From: Billington and Langho Parish Clerk <blparishclerk@outlook.com>
Sent: 24 December 2020 17:11
To: Planning
Subject: 3/2020/1085

Whilst the Parish Council have no objections to the plans could the following be considered:-

PROPOSED SITE PLAN SCALE 1:100

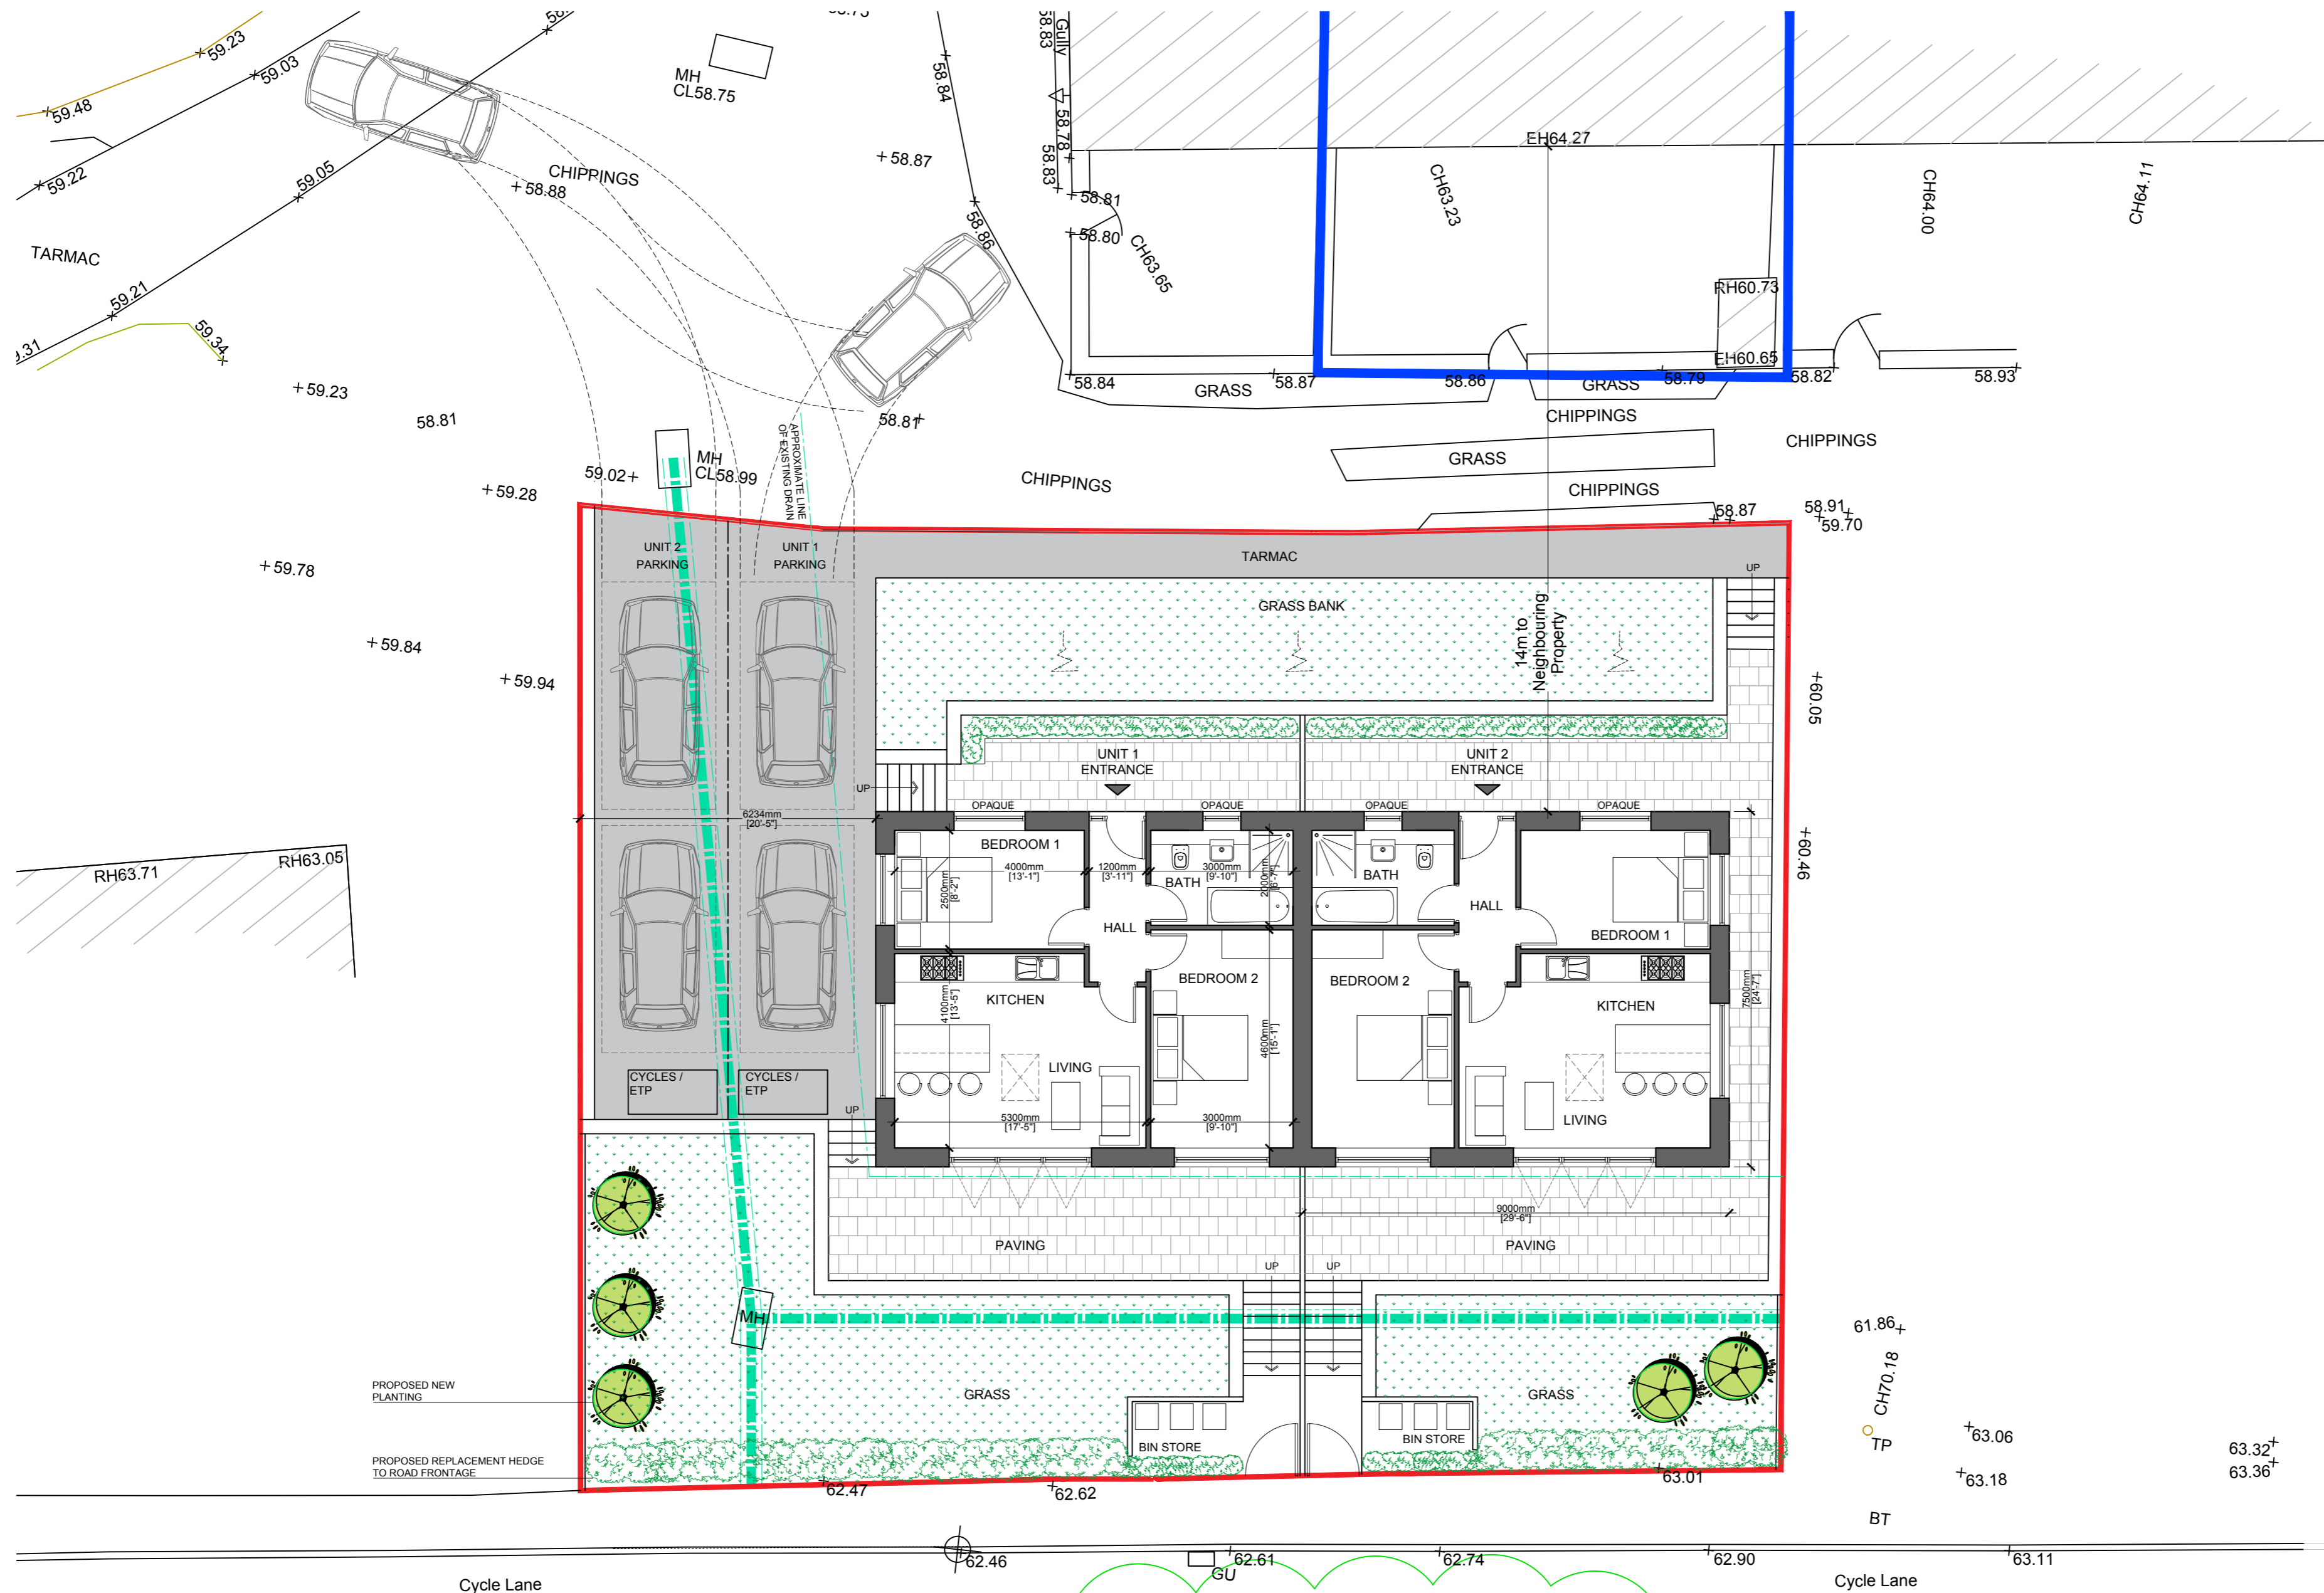
1. The design of the proposed bungalows would be in keeping with the general appearance of Bank Cottages, but it IS a tight site. The Parish Councils no objects is to be subject to comments from the existing residents of that end of Bank Cottages. Application says that these buildings will be no closer than 40 feet to existing cottages, but site looks closed in, if you look at it from the road.
2. Is visibility from the A666 good enough and safe for this application, this is in an awkward place just near the railway bridge.
3. Billington village is currently suffering with water supply problems . The Parish Council requests that RVBC should send the plans to United Utilities with the simple question 'is it happy to supply water to 2 extra properties off the main pipeline?'"
